COMMUNITY DEVELOPMENT DEPARTMENT
501 Delta Avenue ♦ Marysville, WA 98270 ♦ (360) 363-8000

Re: White Barn – Lot 8 Non-Project Action BSP – *Technical Review 1*
PA22043

After review of the preliminary White Barn – Lot 8 Non-Project Action Binding Site Plan (BSP), the Planning Division has the following comments:

DRAWN BY:	DATE:	DRAWING FILE NAME:	SCALE:	JOB NUMBER:	SHEET:
NSY	10-21-22	C22-256V-BSP	N.T.S	C22-256	1 OF 3

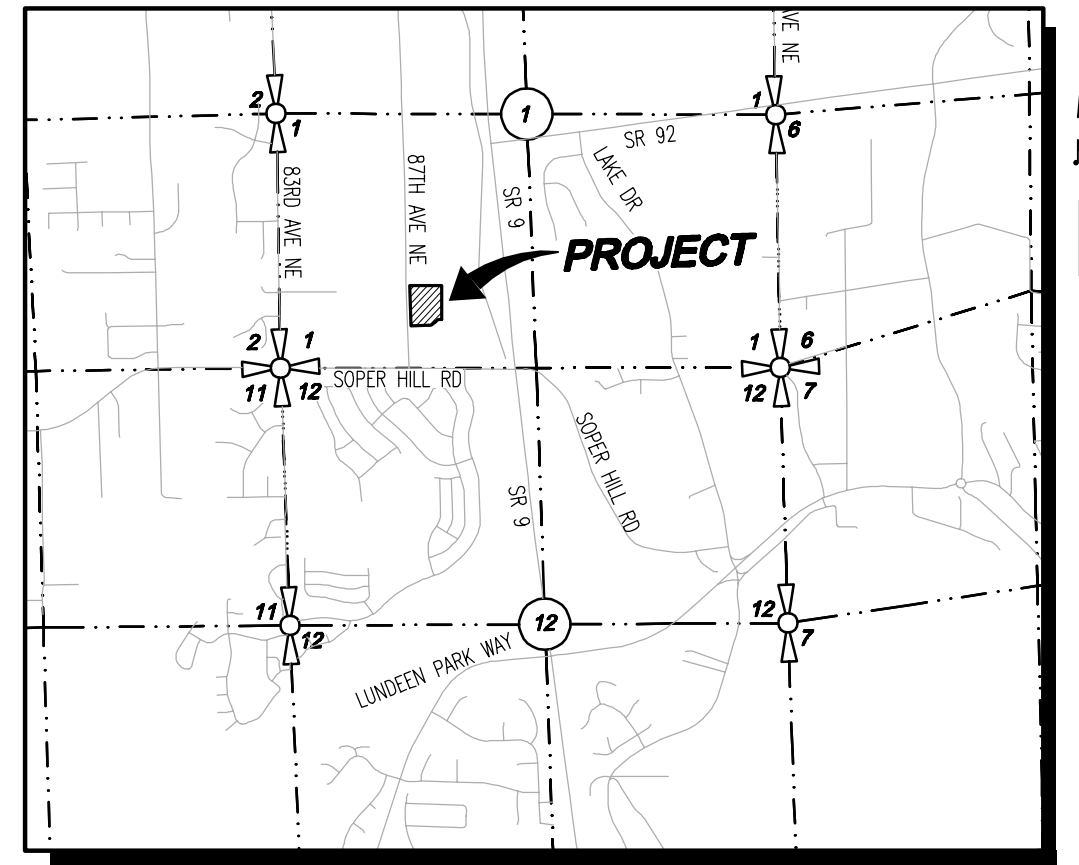
1. Provide file number PA22043 on all future plan submittals.
2. Amend Sheet 1 of 3, as follows:
 - a. Amend title to read "WHITE BARN LOT 8 NON-PROJECT BINDING SITE PLAN."
 - b. Add the following language as the third paragraph under DEDICATION:

That said dedication to the public shall in no way be construed to permit a right of direct access to 87th Avenue NE from lots numbered 8 & 10 nor shall the city of Marysville or any other local governmental agency ever be required to grant a permit to build or construct an access of approach to said street from said lots.
 - c. Add the following RESTRICTIONS:

No further subdivision of any lot without resubmitting for formal binding site plan procedure.

All landscaped areas in public rights-of-way shall be maintained by the developer and his successor(s) and may be reduced or eliminated if deemed necessary for or detrimental to city road purposes.

The location and height of all fences and other obstructions within an easement as dedicated on this binding site plan shall be subject to the approval of the Director of Public Works or his designee.
 - d. Provide a little more space (height) in order to hand write in dates, month, year and signature lines, including COMMUNITY DEVELOPMENT APPROVAL, CITY ENGINEER APPROVAL, MAYOR APPROVAL, TREASURER'S CERTIFICATE AND AUDITOR'S CERTIFICATE.
3. Amend the title on Sheet 2 of 3 to read "WHITE BARN LOT 8 NON-PROJECT BINDING SITE PLAN."
4. Amend Sheet 3 of 3, as follows:
 - a. Amend title to read "WHITE BARN LOT 8 NON-PROJECT BINDING SITE PLAN."

DRAWN BY:	DATE:	DRAWING FILE NAME:	SCALE:	JOB NUMBER:	SHEET:
NSY	10-21-22	C22-256V-BSP	1"=50'	C22-256	3 OF 3

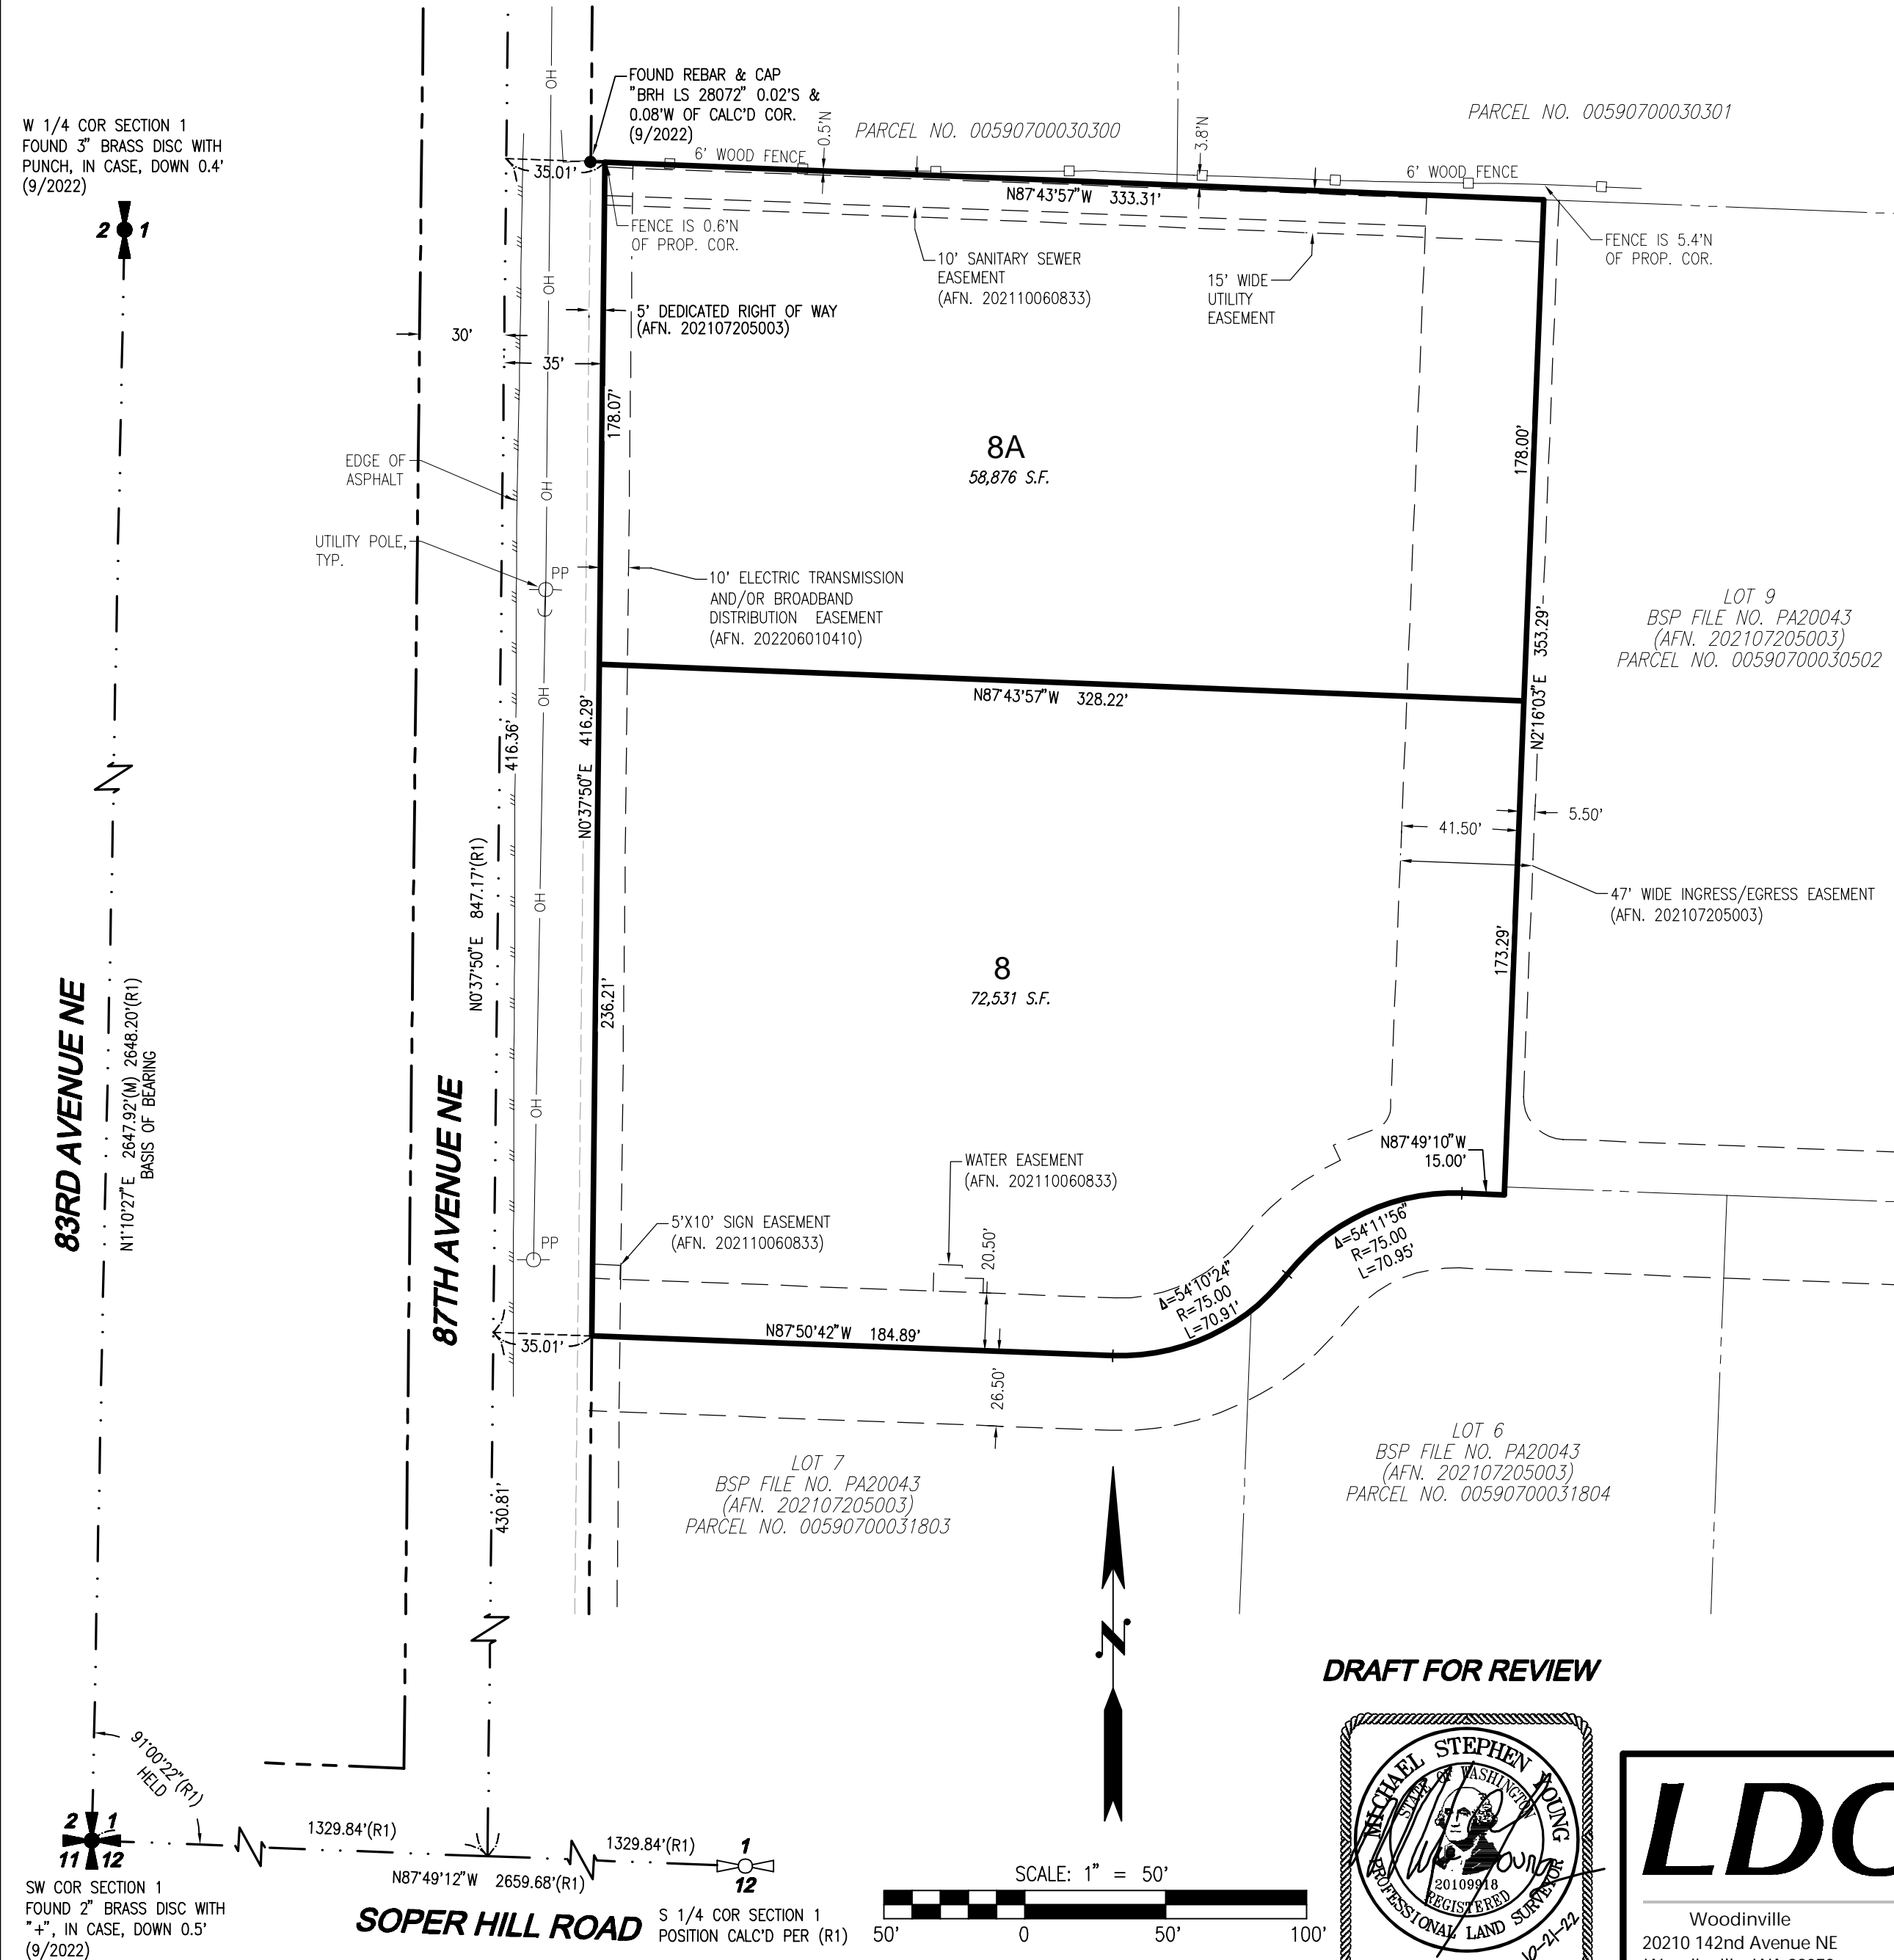
b. Amend to Read Lot 8 & Lot 10 (not 8A).
